From: Ian Hayward [REDACTED]
Sent: 06 June 2018 22:12
To: Anita Gardner
Subject: RE: Planning Consultation on: LU/67/18/PL

TO:	Arun District Council FAO: Mrs A Gardner
FROM:	Highways, WSCC
DATE:	31/05/2018
LOCATION:	14-18, Surrey Street, Littlehampton, West Sussex, BN17 5BG

SUBJECT:	LU/67/18/PL Change of use of part of public highway for external seating area at front comprising of 4 No. tables & 8 No. chairs. This application may affect the setting of a listed building. More information.
DATE OF SITE VISIT:	n/a
RECOMMENDATION:	Advice / Modification
S106 CONTRIBUTION TOTAL:	n/a

03

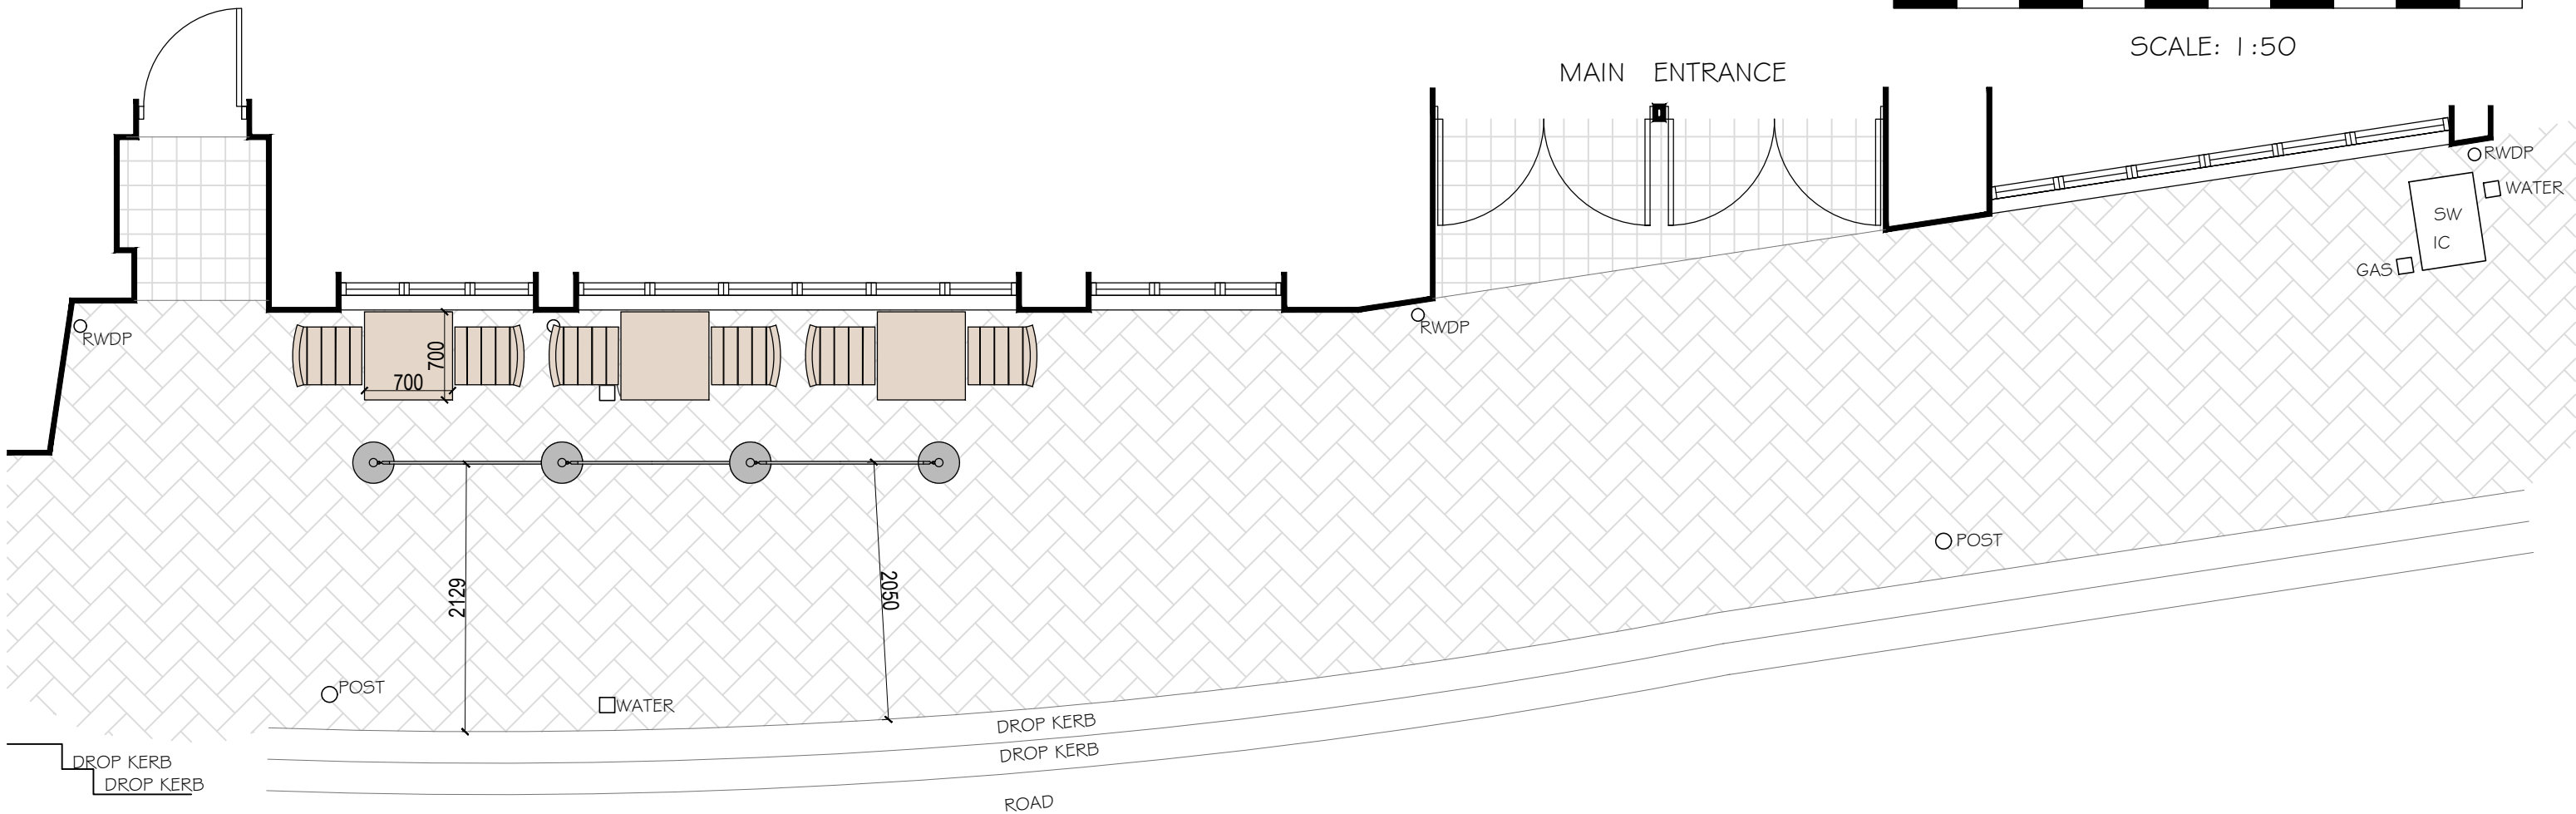
After inspection of the revised plans the proposed would still result in a narrowing of the footway to circa 1.8 metres once the stands for the rope and pole barriers have been taken into consideration.

A post is annotated at the southern extent of the frontage, using desktop evidence this post was removed some when between 2014 and 2015. The applicant should check this detail and remove this annotation if the post is no longer in place.

The Local Highways Authority would reiterate that Manual for Streets advises a minimum footway width of 2.0 metres. This is expanded upon in section 3.1 of the DFT publication 'Inclusive Mobility' which states the following regarding footway widths:

I note the frontage of the public house does provide the opportunity to provide a reduced level of tables and chairs while retaining minimum acceptable footway widths across the frontage as advised above. The Local Highways Authority would advise that the rope and pole barriers are removed or pushed back to provide maximum footway with and/or further reducing the quantity of tables and chairs provided.

After review of the latest plans, in particular plan 7508 03 B, I can confirm the concerns raised in correspondence dated 12/04/2018 & 31/05/2018 have been overcome.
